**From:** [Rob Green](#)  
**To:** [Price, Robert](#)  
**Cc:** [Wilson, Andy](#); [Betts, Simon](#); [A38 Derby Junctions](#)  
**Subject:** RE: A38 Derby Junctions - SoCG McD  
**Date:** 02 April 2020 11:50:45  
**Attachments:** [image001.png](#)

- 1a. My client does not agree to the proposed closure of the A38 access
- 1b. The outcome of the A52 junction modelling is agreed, however, concerns remain over the proposed junction layout and its ability to operate safely. Should you wish to split this point into two elements, then we will agree the junction modelling

The
 ADL PROPOSED ACCESS AND EGRESS
 OFF HIGHWAYS ENGLAND SLIP LANE

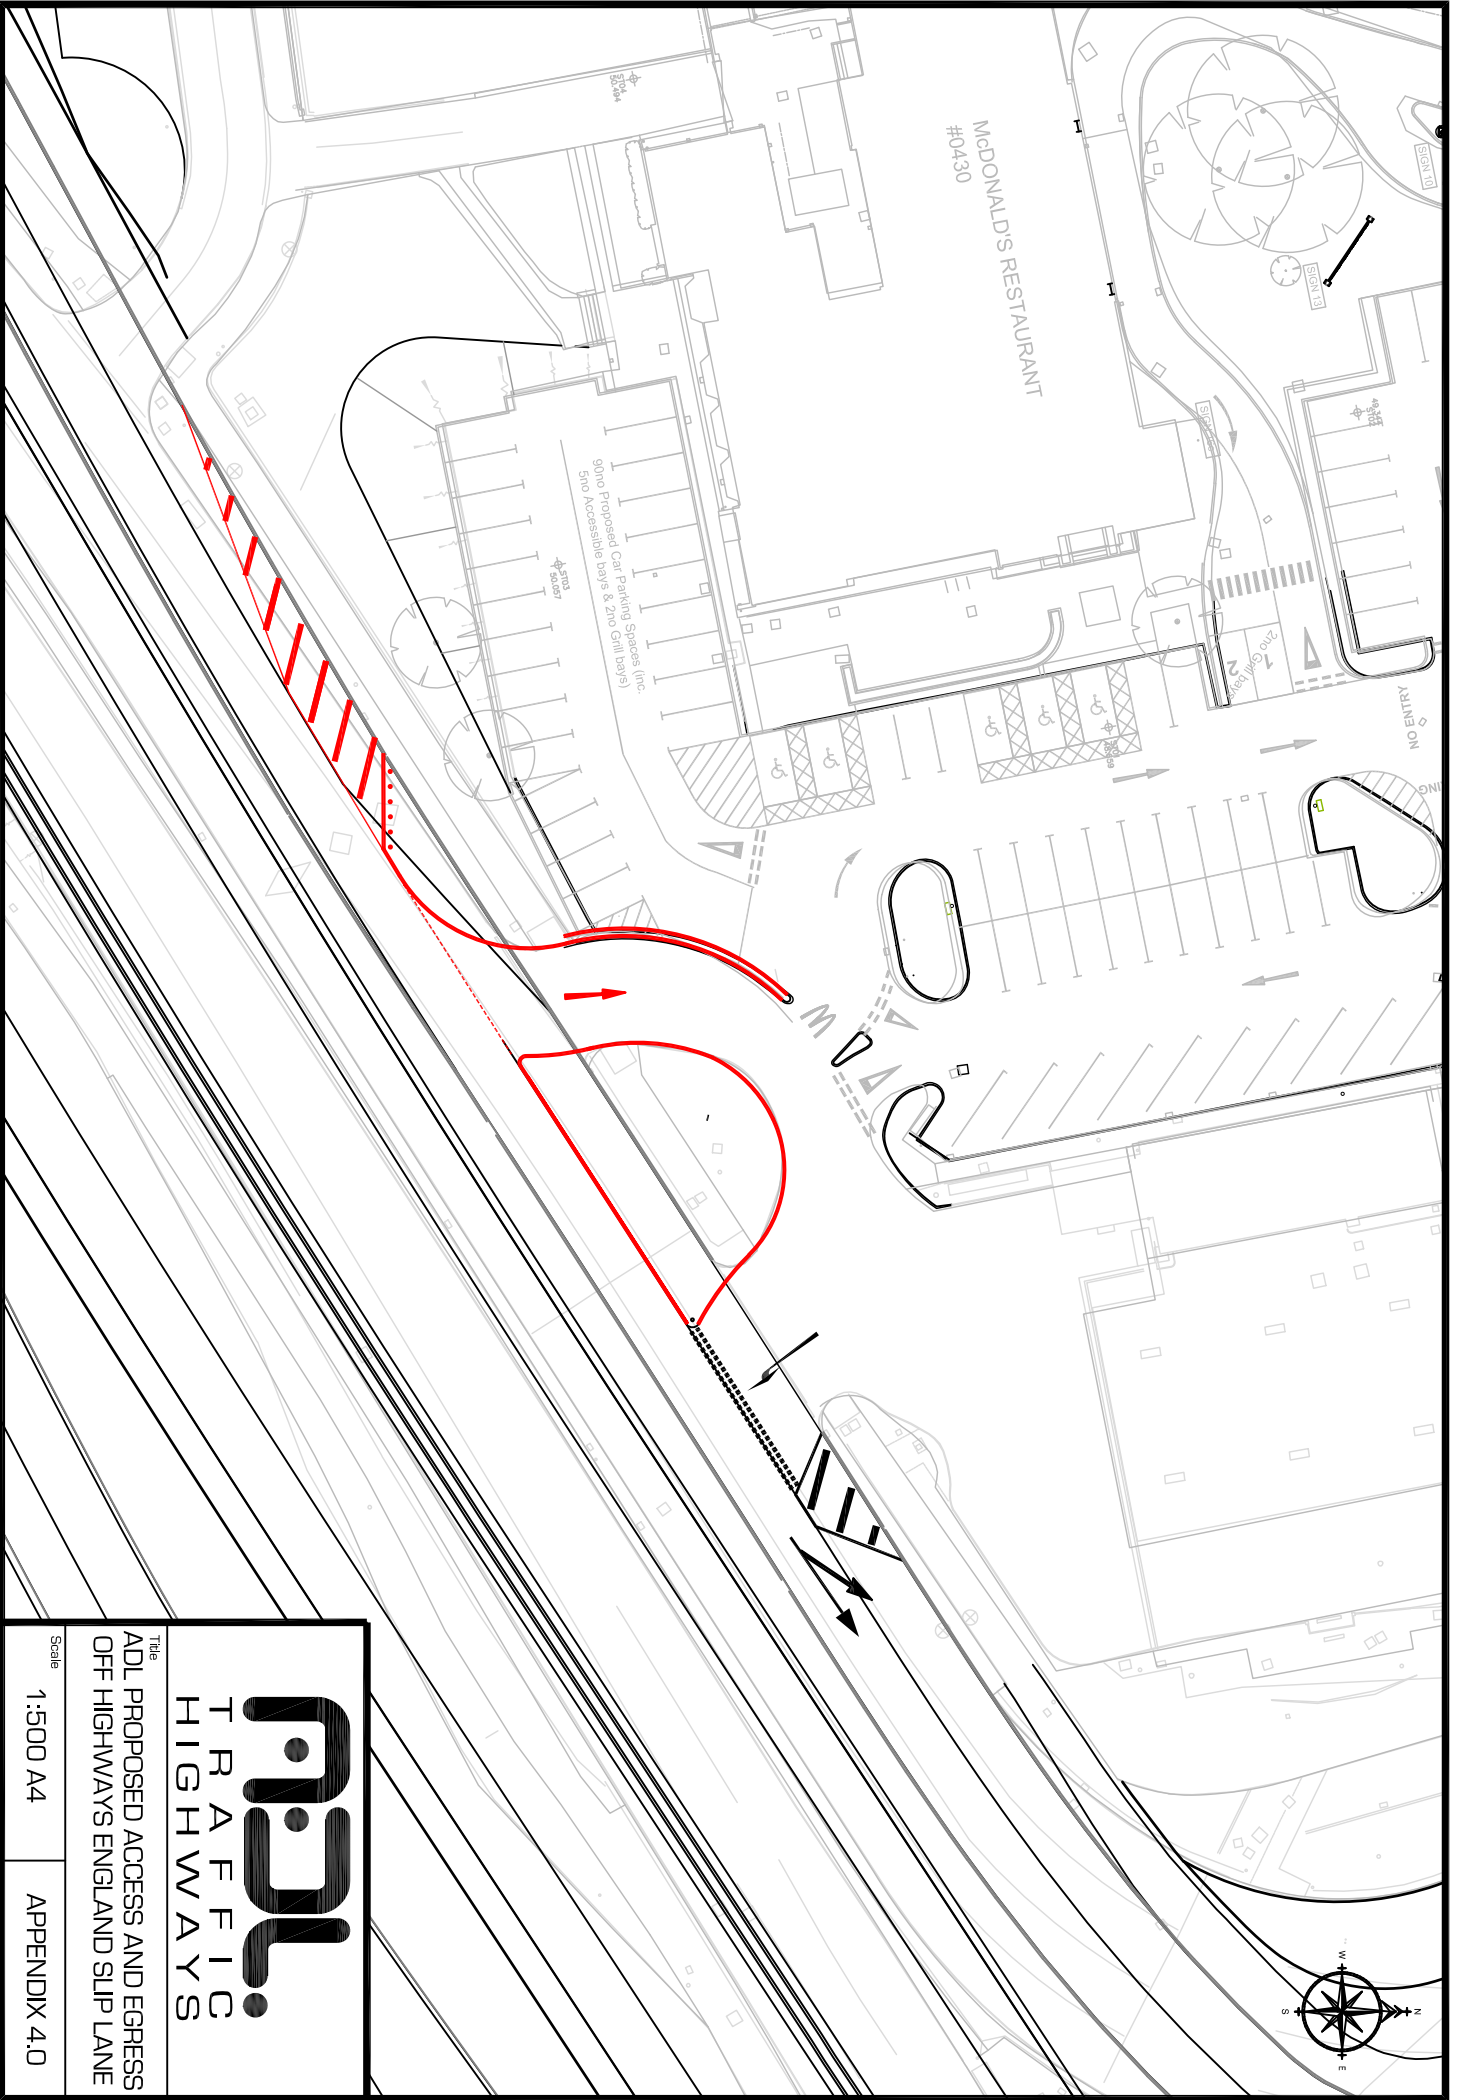
- 3b. Remains under discussion, McDonald's remain concerned about the geometric standards applied to the access/egress to the A52, in particular what would happen behind the stopline, as one moves into the McDonald's and Euro Garages site and the ability for this to operate safely and without congestion.
